M54 to M6 Link Road

**Review of Proposed Habitat Creation
on Land Owned by Allow Ltd.**

September 2020

Quality Management	
Client:	Allow Ltd.
Project:	M54 to M6 Link Road
Report Title:	Review of Proposed Habitat Creation on Land Owned by Allow Ltd
Project Number:	ECO-5912
File Reference:	5912 EcoReview dv4
Date:	25/09/2020

Drawing Number HE514465	Originator -ACM	Volume -EGN	Rev P03
Location M54_SW_PR_Z	Originator -DR	Volume -EG - 0022	Rev P03

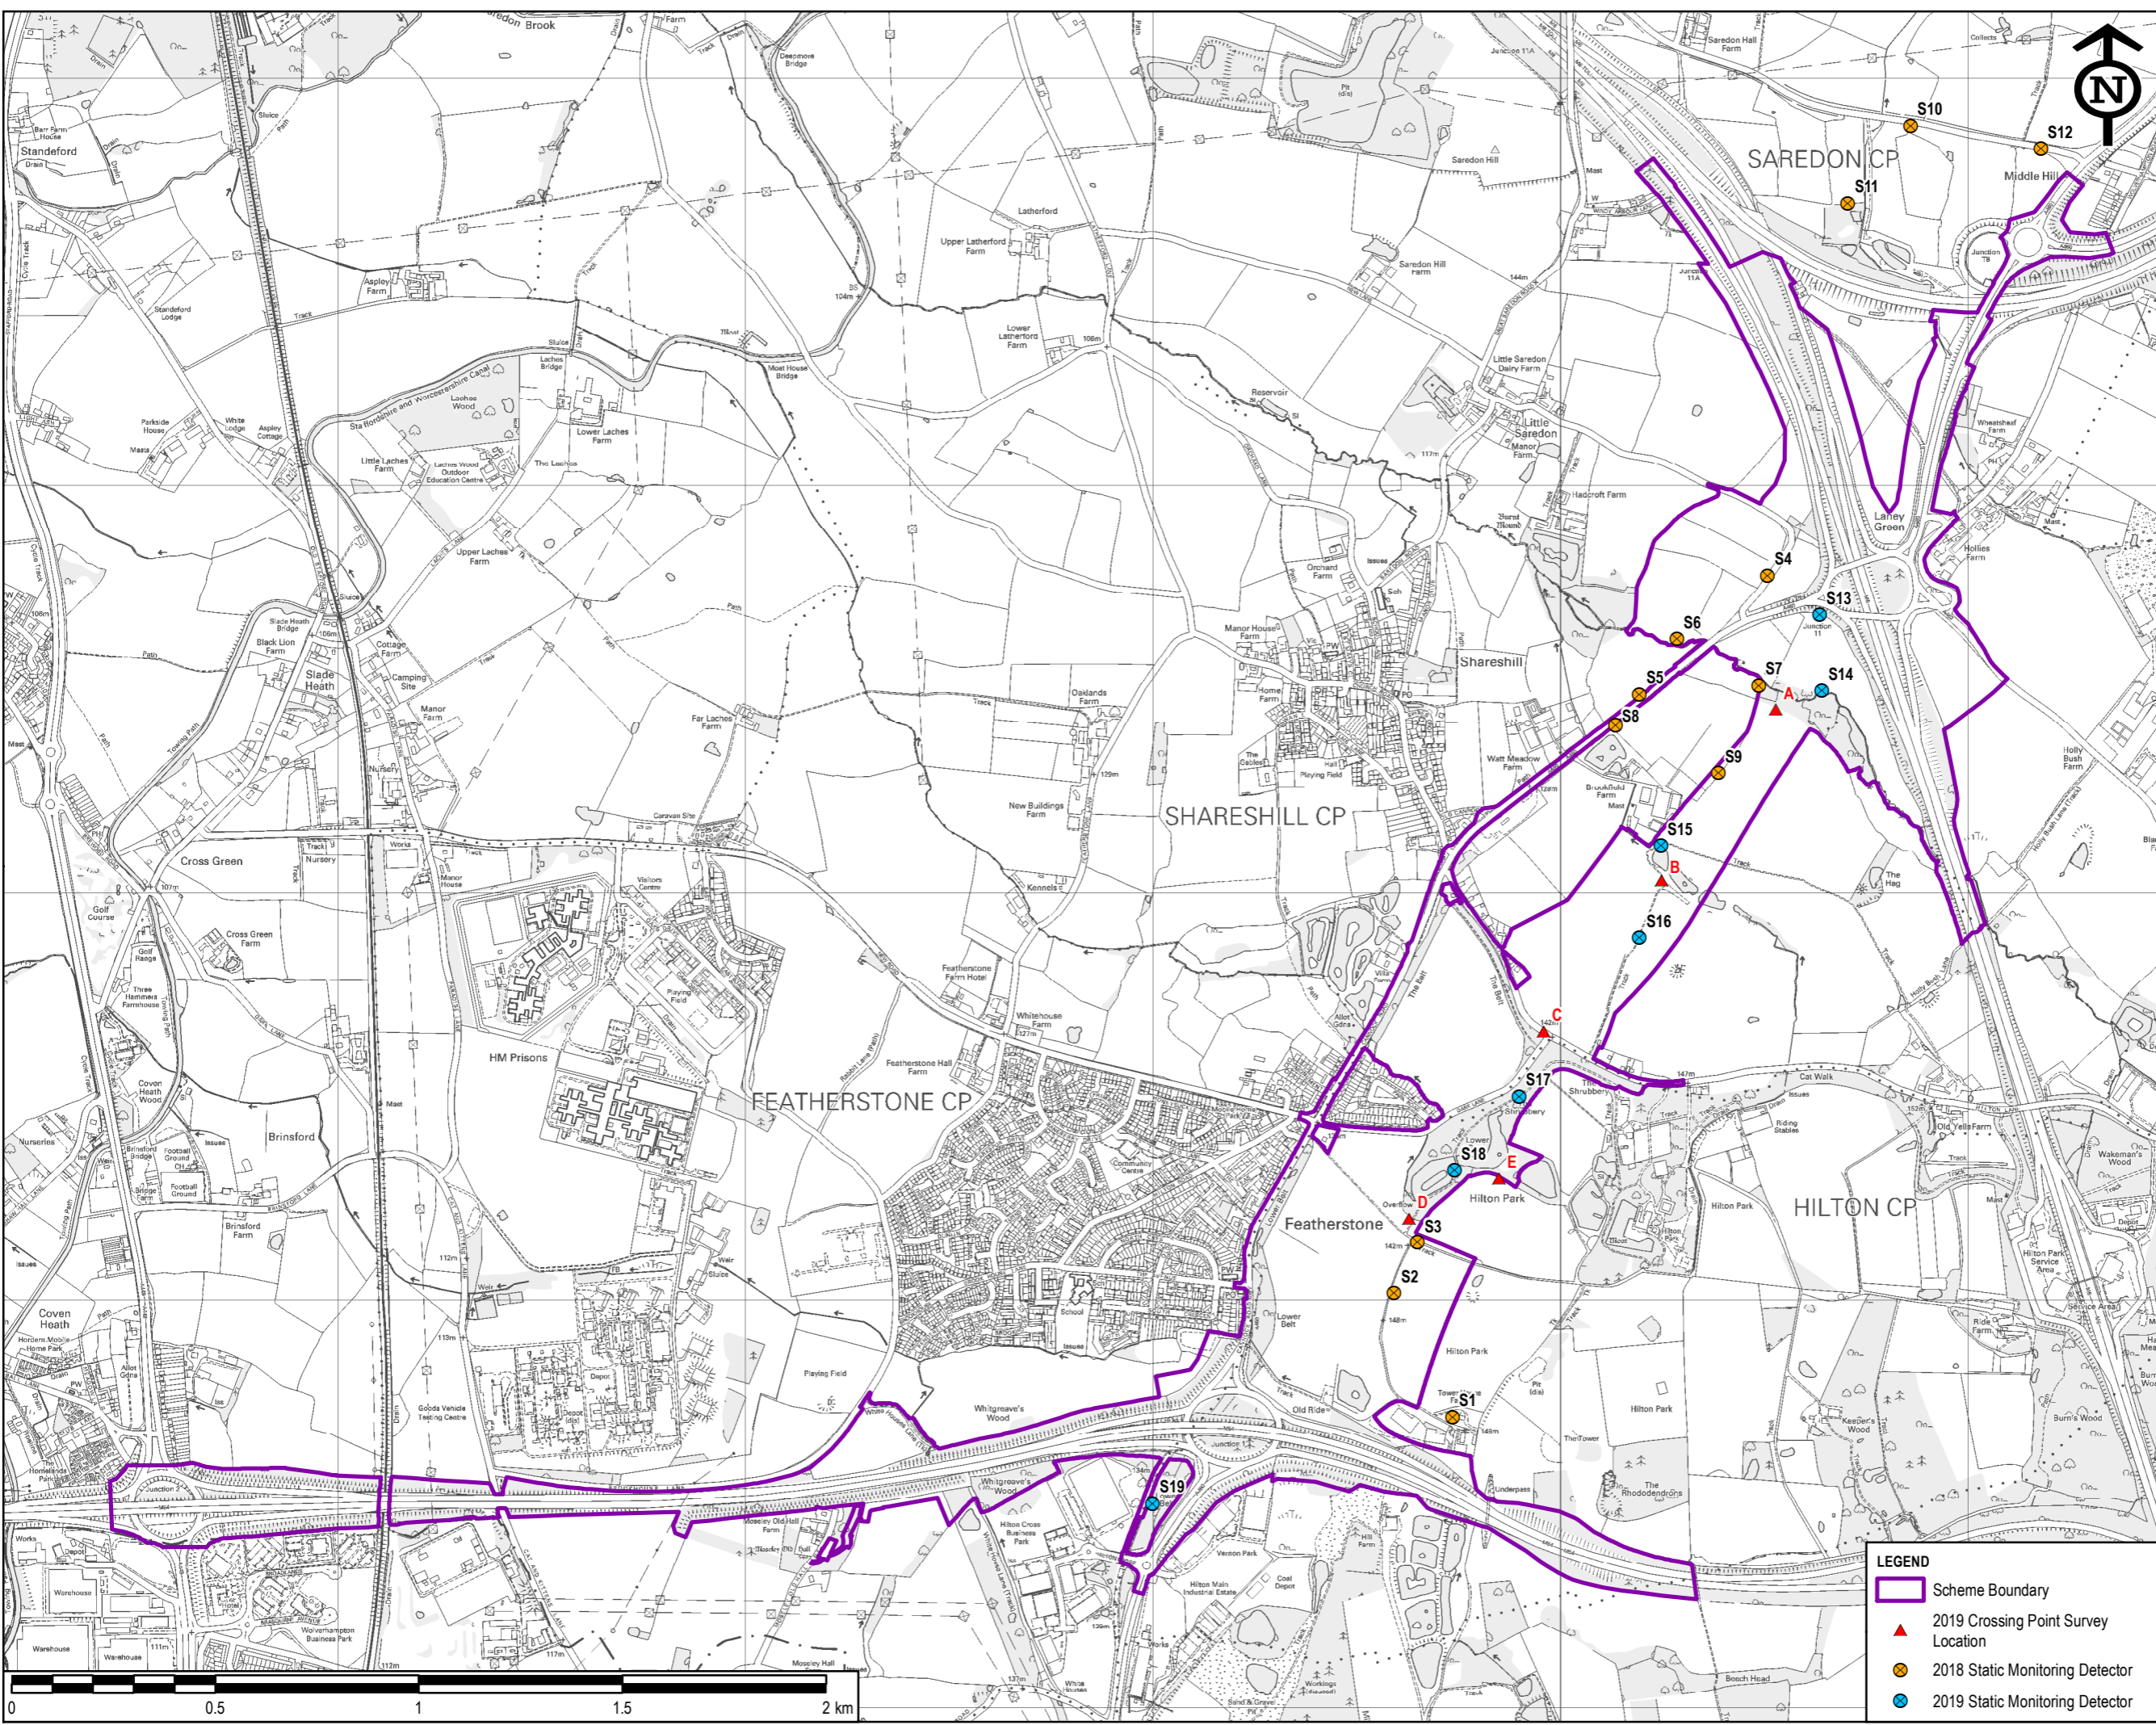
- 3.4.3 Figure 8.15 does not show any static detectors in the location of the proposed habitat creation associated with Transect 5 (*i.e.* to the west of the scheme). These would have recorded activity levels here and determined the baseline importance of these areas to bats. As it stands, current use/importance of these areas is not known. Indeed, paragraph 8.9.26 of Chapter 8 states that open fields of arable and poor semi-improved grassland are associated with lower levels of bat activity. As such, their current importance, and future potential benefit, to the local bat population is not quantified. Nonetheless, it does appear clear that existing bat activity is highest in the east and accordingly the statement in Paragraph 4.5.3 of the EMR, that habitat creation measures are appropriately sited for bats, appears incorrect.

- 3.4.6 It is recommended that the location of the provision of bat mitigation is revisited and it relocated to the east of the link road.

Plot Date: 11 November 2019 09:54:49  
File Name: \\UK62spfsa001\1\ie\ENVIRONMENT\Practice Areas\GIS\Projects\M54\M6 Link\Workspace\Stage 3 Figures\Ecology\PO2 Template\HE514465-ACM-EGN-M54\_SW\_PR\_Z-DR-EG-0043 - GCN Desk Study Records.mxd

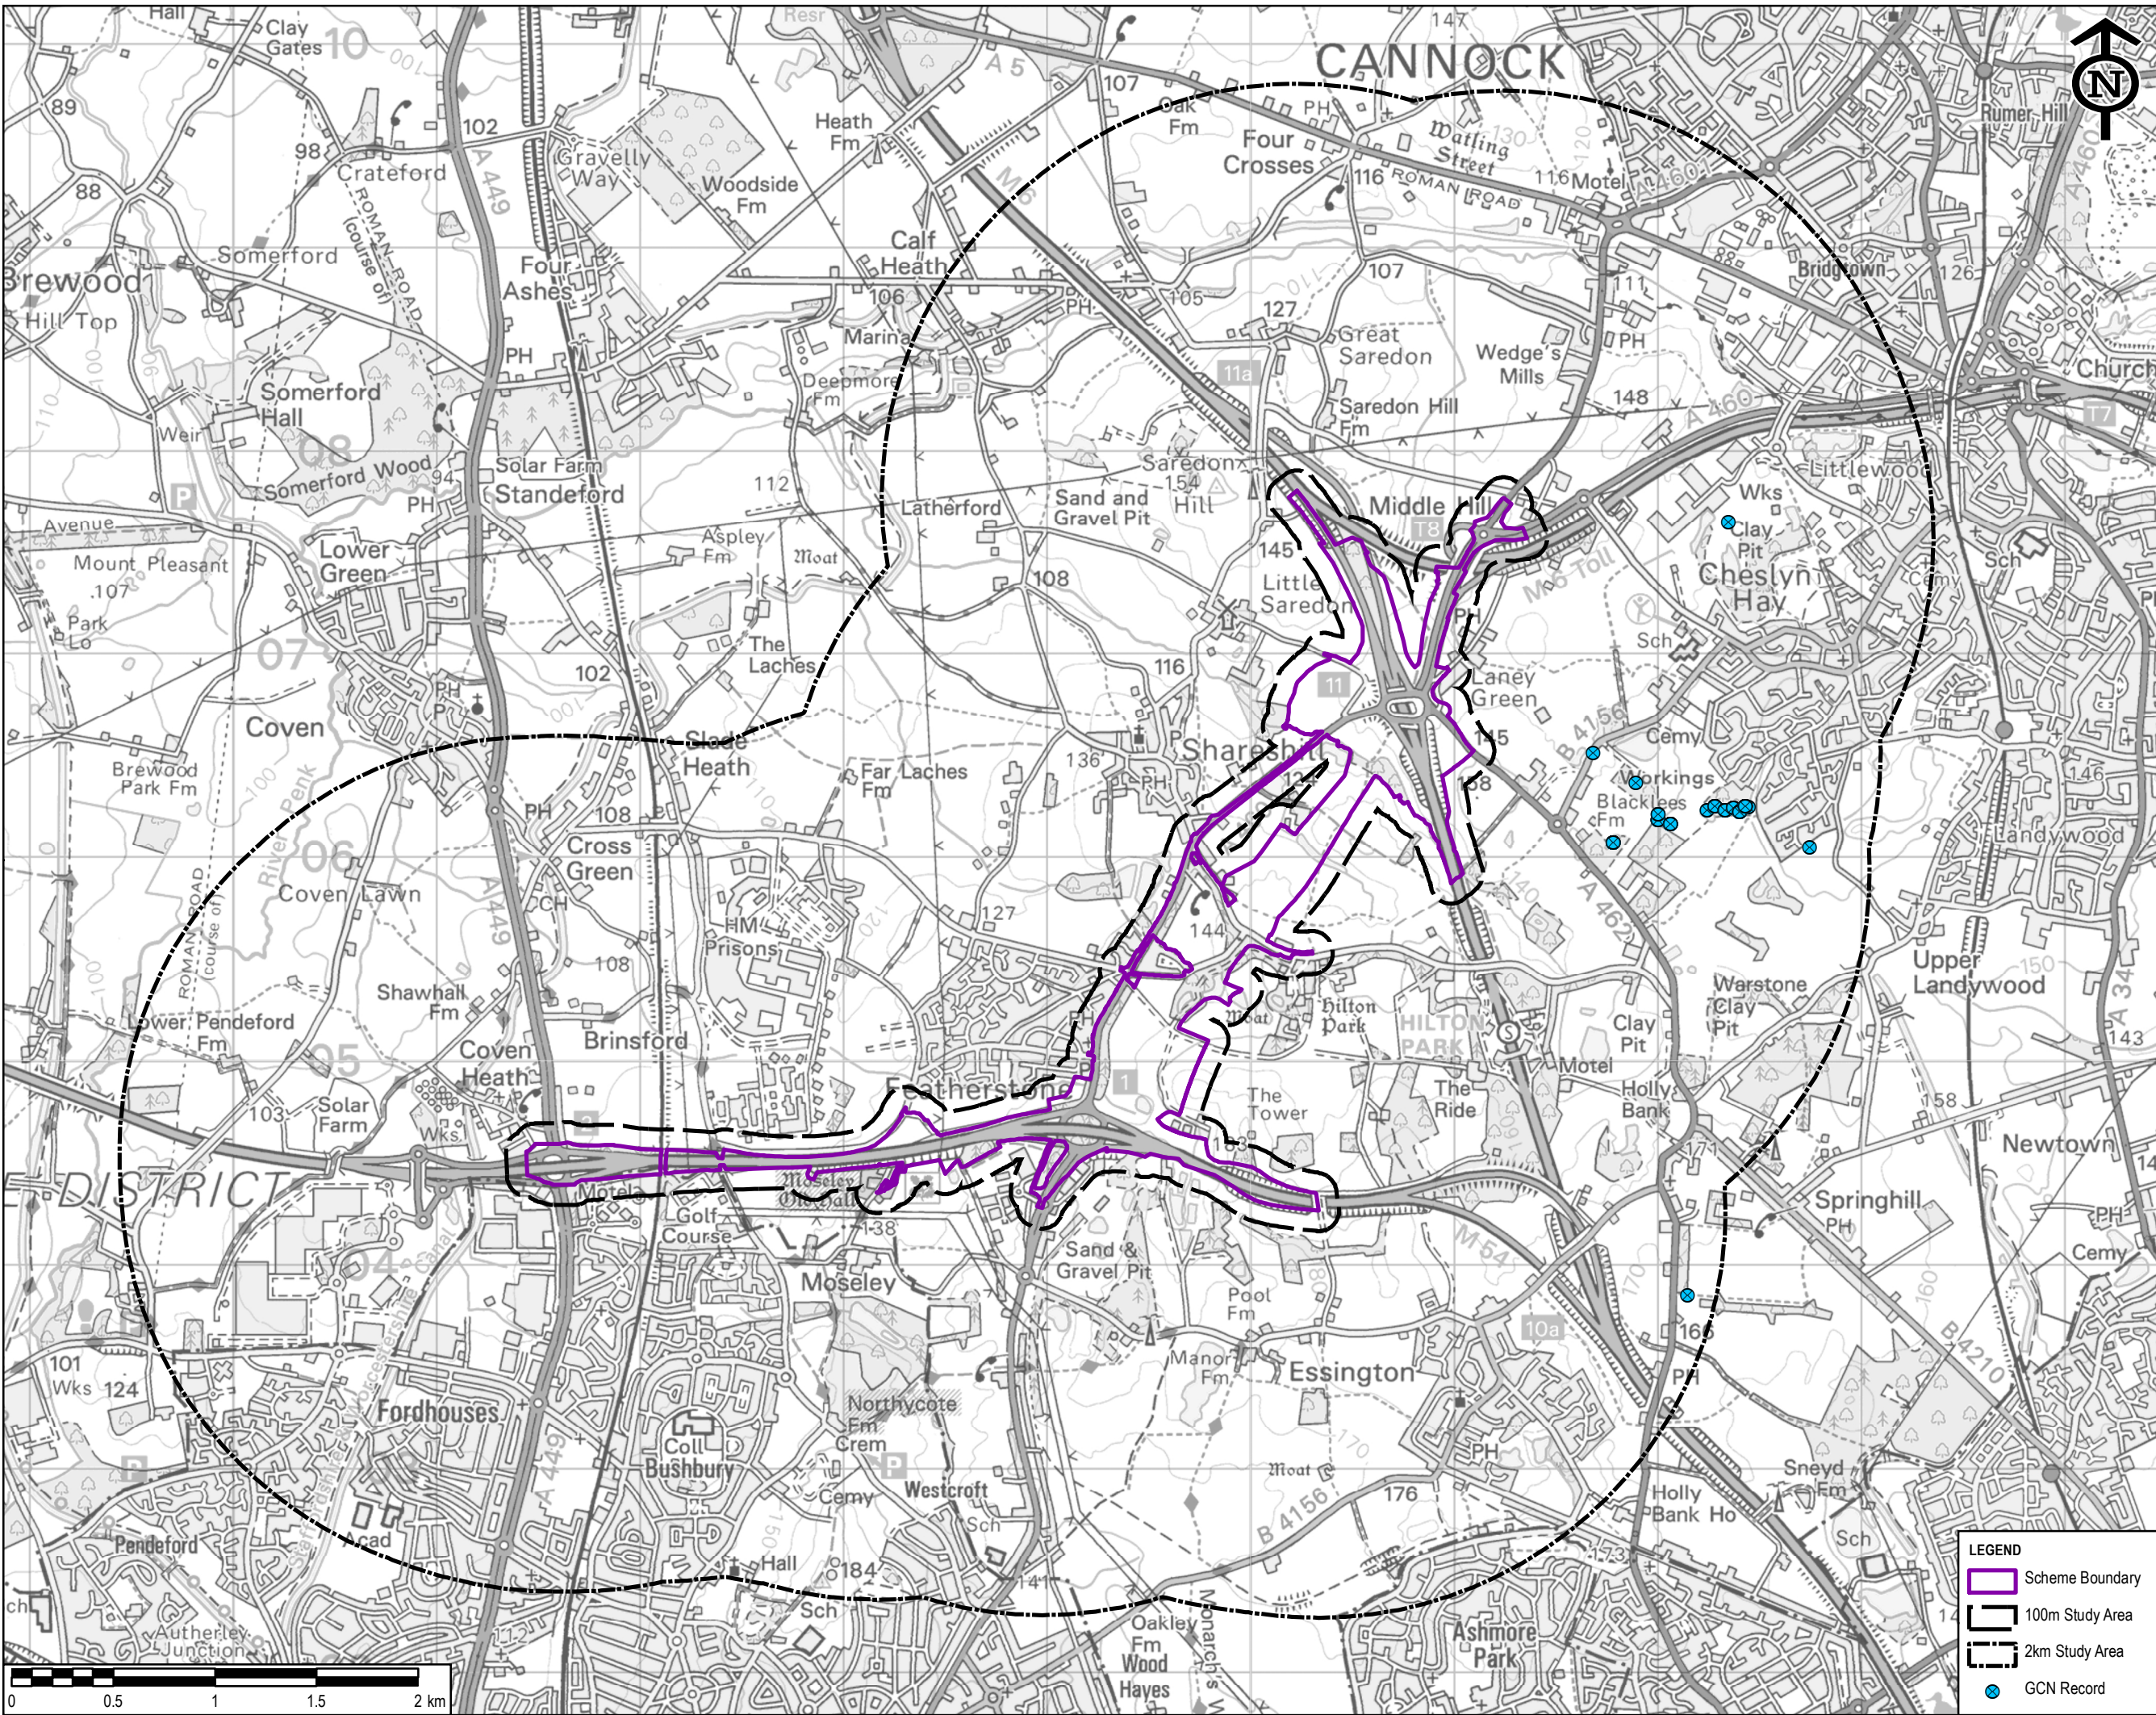
2.5.1 Figures 8.28 and 8.29 of the ES show that historic, and current, known presence of Great Crested Newt is greatest to the east of the proposed scheme. However, at least five of the proposed ‘ecological ponds’ will be created to the west of the scheme. Currently, due to the absence of survey data, the exact number of compensatory ponds required is unknown. In addition, based on the known local distribution of GCN being to the east of the scheme, the locations of the proposed ponds, and their ability to effectively contribute to Great Crested Newt conservation (and alleviation of predicted project effects) is inappropriate. New ponds would not link to existing populations of Great Crested Newts and hence would not serve to mitigate effects from losses to the scheme. This is particularly important for this species which has a population ecology that functions as a meta-population, typically requiring clusters of ponds for long term population success. This allows temporary losses of a population from an individual pond, for example due to an environmental event, to be recovered by colonisation by GCN from a nearby pond.

2.8.1 All background records for the species (Figure 8.28 of the ES) and ponds confirmed to support GCN (confirmed through eDNA surveys for the scheme – see ES Figure 8.29) are located to the east of the proposed scheme. As such, the appropriateness and effectiveness of creating compensatory habitat for this species to the west of the scheme is in question. If the location of compensatory ponds is inappropriate, then the current habitat creation proposals for land within 500m of these ponds (designed to benefit the species) should also be reviewed alongside proposed pond locations. This must all be based on up-to-date survey information⁶.

2.5.2 It is recommended that the siting of mitigation is re-visited and this re-located to the east of the scheme.
